Appeal Decision

Appeal Ref: APP/T2350/D/24/3354944

26 Whalley Road, Langho, Lancashire BB6 8EJ

- The appeal is made under section 78 of the Town and Country Planning Act 1990 (as amended) against a refusal to grant planning permission.
 - The appeal is made by Ms Ciara Beckett against the decision of Ribble Valley Borough Council.
 - The application Ref is 3/2024/0614.
 - The development proposed is described as 'Retention of existing single storey side extension, with associated alterations including the provision of a pitched roof.'
-

DRAWING NO 709/3

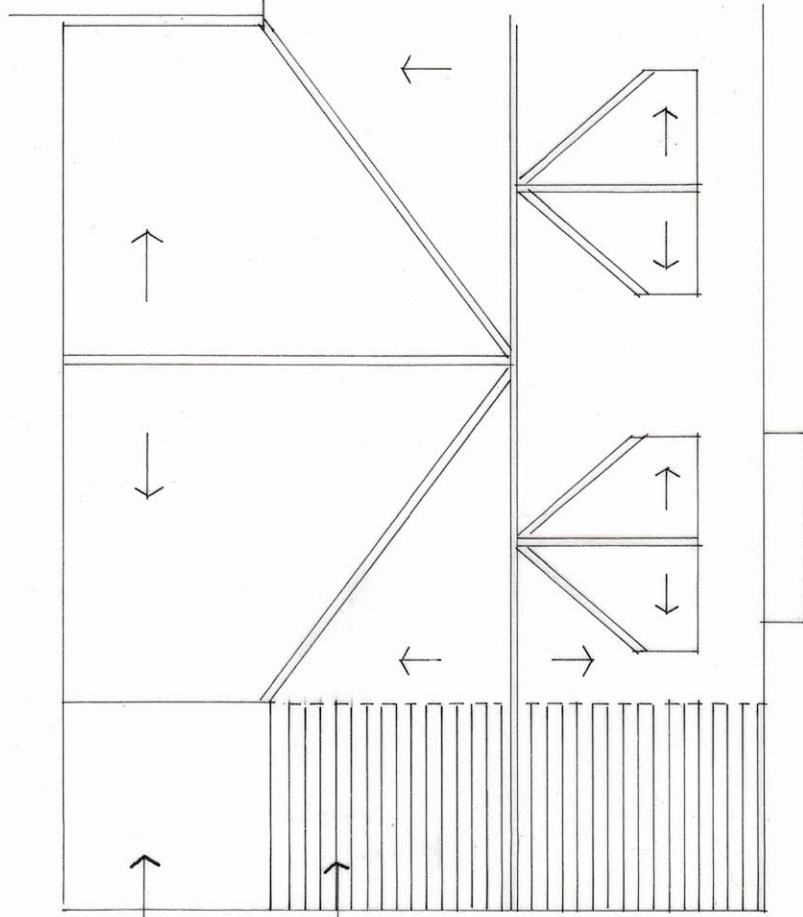
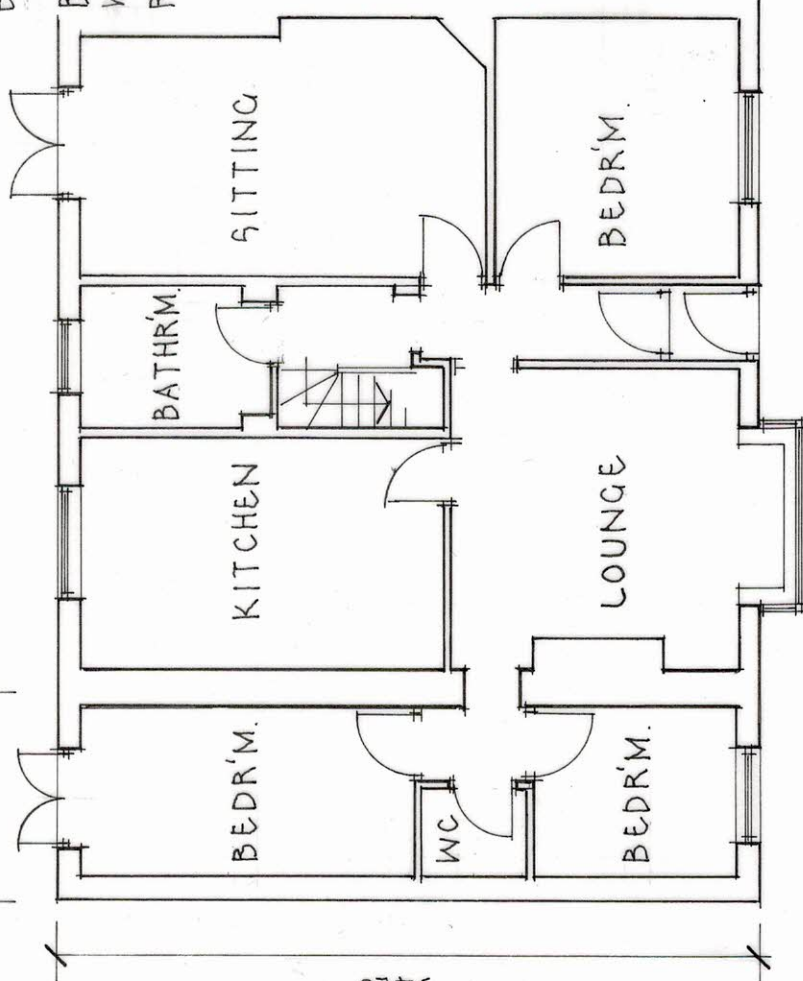
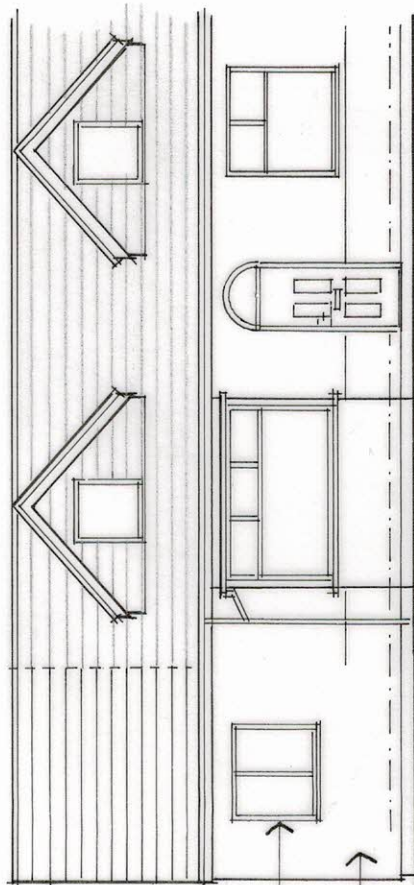
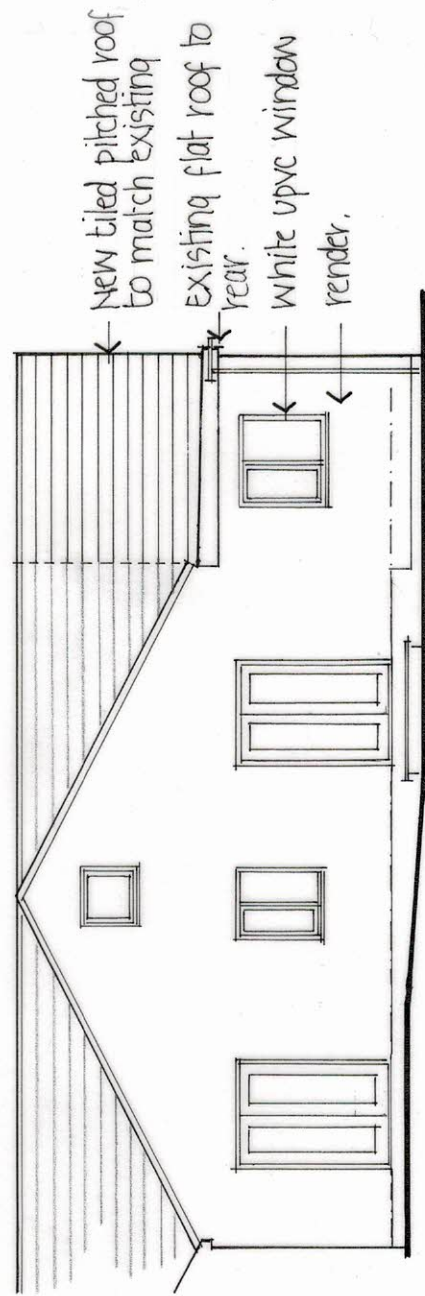
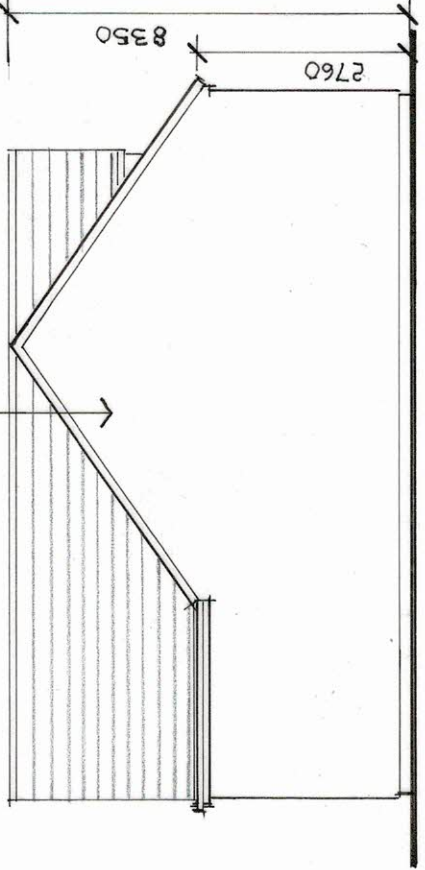
prominent above this, with the fascia boards of the flat roof sitting above the eaves of the original gabled roof. It is proposed to replace this flat roof with a gable to match the roof form of the host bungalow. The new gable would extend the current roof form sideways with matching pitch, eaves and ridge heights. However, it would leave a small section of flat roof adjacent to an existing rear projection.

7. By extending the full depth of the existing bungalow, and continuing the ridgeline of the original roof, the side extension would result in a significant increase in the bulk and massing of No 26 on the Springdale Road frontage. Because of its corner location it would not lead to a terracing effect, but it would nonetheless appear an overly dominant addition to the host bungalow particularly from Springdale Road travelling toward Whalley Road. From here it would be viewed alongside the smaller, lower bungalow on the opposite corner. Further, because of its depth close to the Springdale Road boundary, the massing of the extension would be unduly prominent on the corner travelling south-west on Whalley Road. It would appear a discordant addition, out of character with the modest scale of development in the surrounding area.

8. The width of the side extension itself is proportionate in scale to the host bungalow, and the existing stringcourse detail in the render and box bay window offer some limited articulation to the front elevation. However, because the side extension is flush with the front elevation and the proposed gabled roof would continue the eaves and ridgeline of its host, the development would result in an expansive front elevation, which would fail to appear subservient to its host. The fenestration colour and render finish of No 26 differs from its attached neighbour, but there is nonetheless a pleasing uniformity and symmetry to the pair which would also be unbalanced by the massing of the proposed extension.
